Addendum No. 1

RE: Contract ID: C202456

Johnston County (I-5016)

I-95 From North Of US-70 (MP 99.8) To US-301 (MP 107.1)

WBS ELEMENT	SHEET NO.	TOTAL SHEETS
42397.3,STI	2	4
TIP PROJECT	F. A. PROJ. NO.	DESCRIPTION
I-5016

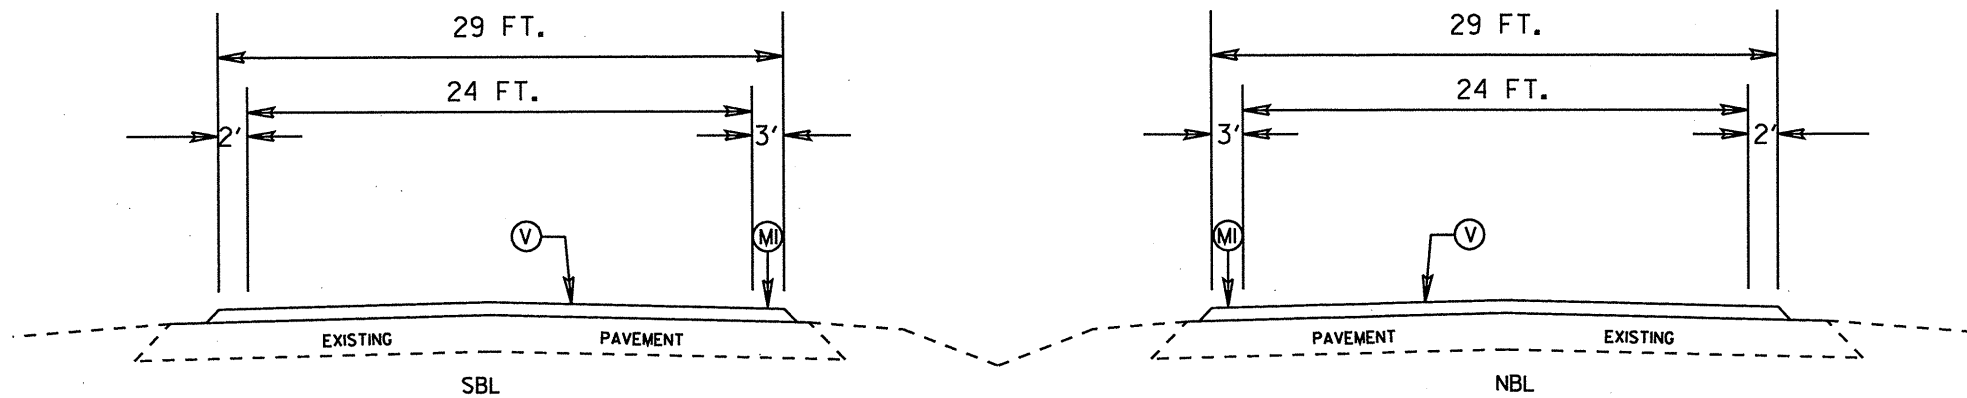
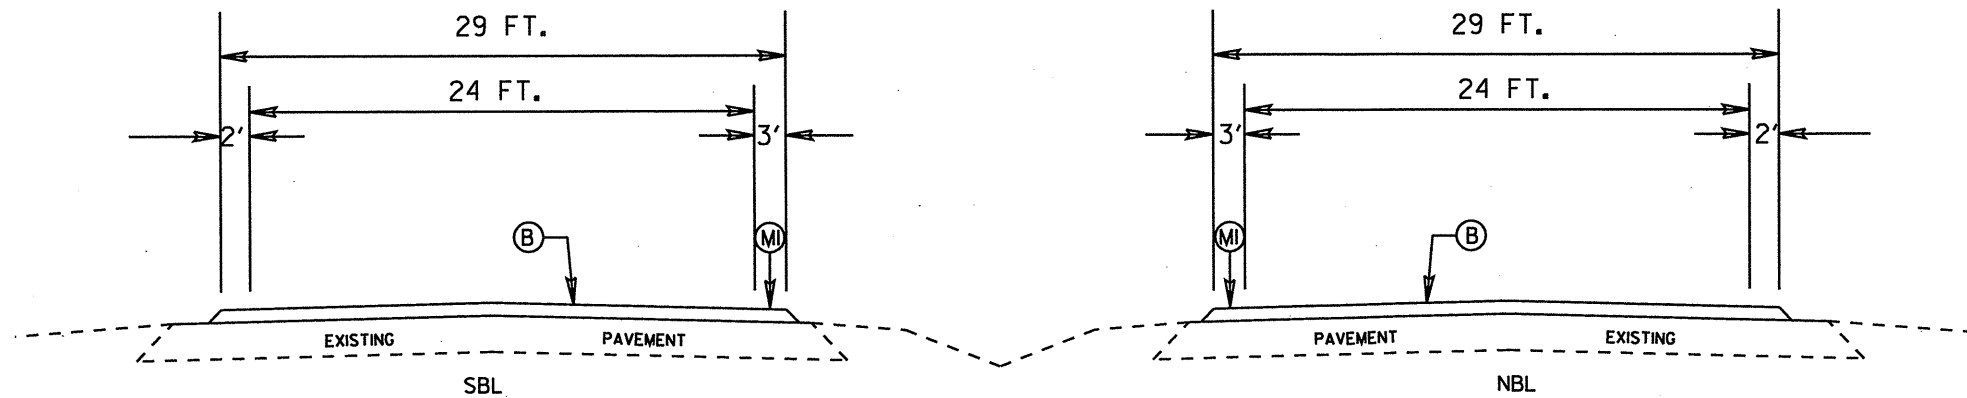
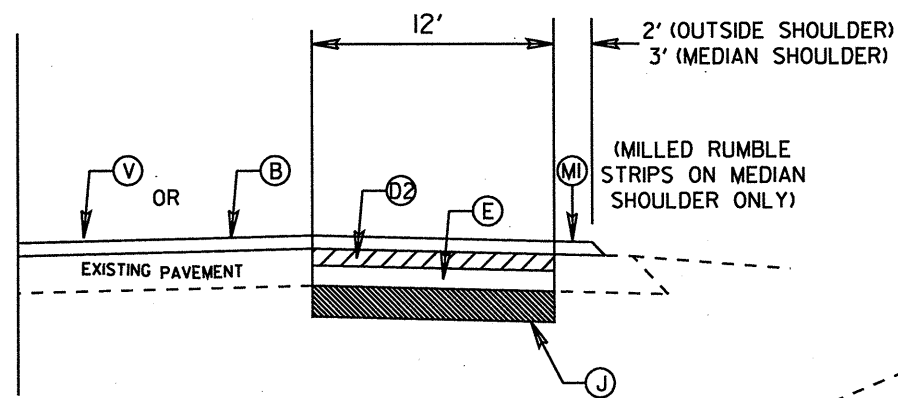
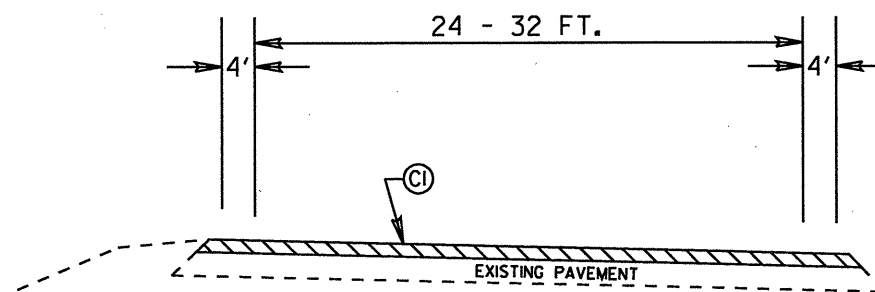
On sheet No. 2 the typical sections have been revised to reduce the width of the overlay, to eliminate milled rumble strips on the outside shoulder and to show an alternate pavement design for "Open Graded Asphalt Friction Course"

PROJECT NO. I-5016 (42397.3.ST1)	SHEET NO. 4	TOTAL NO. 4
--	----------------	----------------

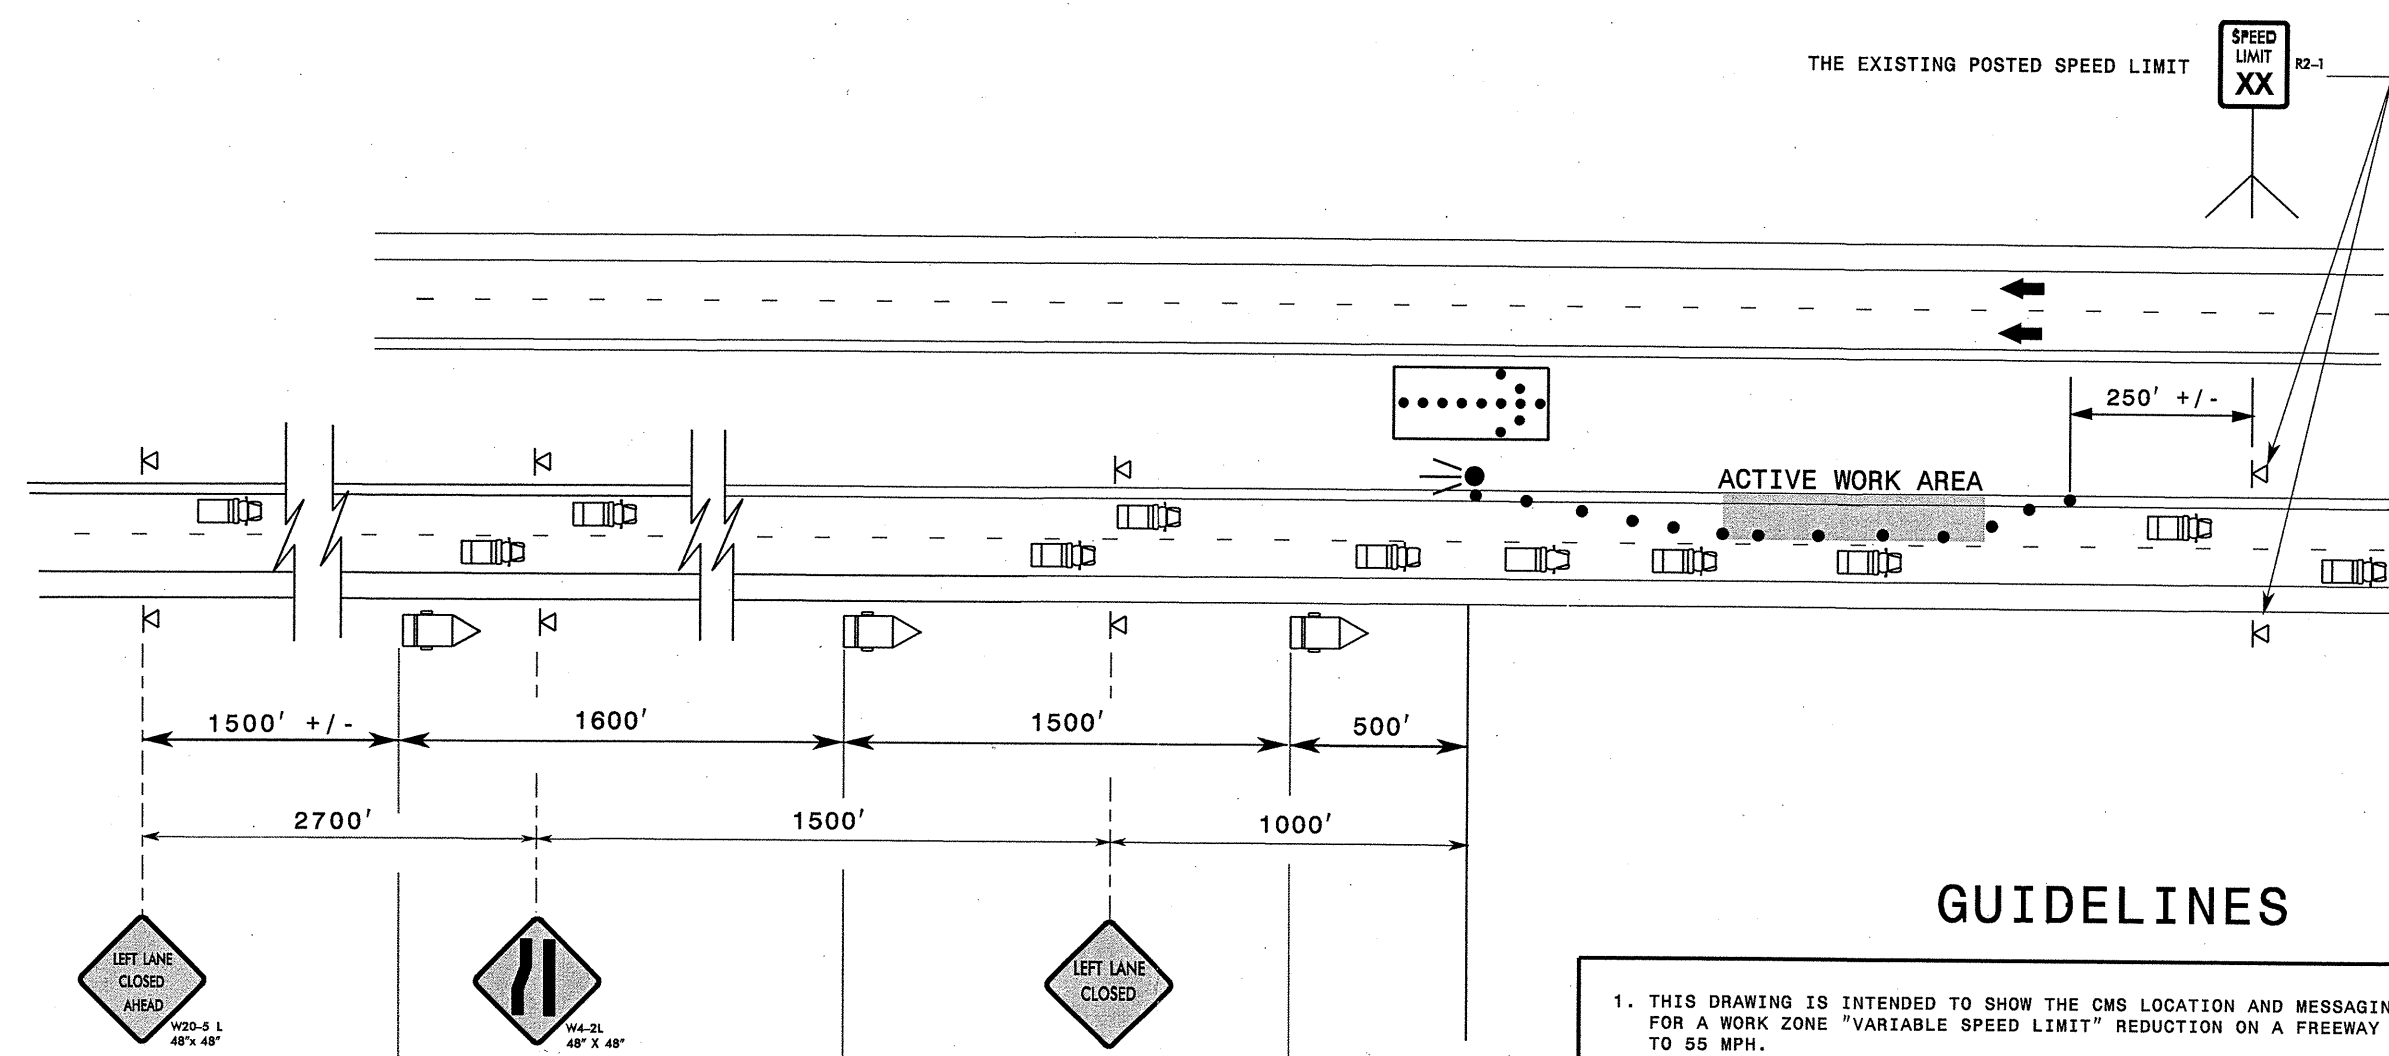
On Sheet No. 4 the Summary of Quantities have been revised to make the appropriate quantity changes to reflect the above noted revisions and to add a column for Seeding and Mulching.

<u>Item</u>	<u>Description</u>	<u>Old Quantity</u>	<u>New Quantity</u>
17-1840000000-E-665	Milled Rumble Strips (Asphalt Cement Conc.)	154,400 LF	77,088 LF
31-6084000000-E-1660	Seeding and Mulching	NEW ITEM	2 ACR
32-1567000000-E-SP (old Line #13)	Asphalt Binder For Plant Mix, Grade PG 70-28	592 TON	500 TON
33-1839110000-E-661 (old Line #15)	Ultrathin Hot Mix Asphalt, Type B	11,400 TON	9,570 TON
34-1839200000-E-661 (old Line # 16)	Application of Ultrathin Hot Mix Asphalt	325,714 SY	250,000 SY
35-1570000000-E-620	Asphalt Binder For Plant Mix, Grade PG 76-22	NEW ITEM	740 TON
36-1663000000-E-650	Open-Graded Asphalt Friction Course, Type FC-2 Modified	NEW ITEM	12,300 TON
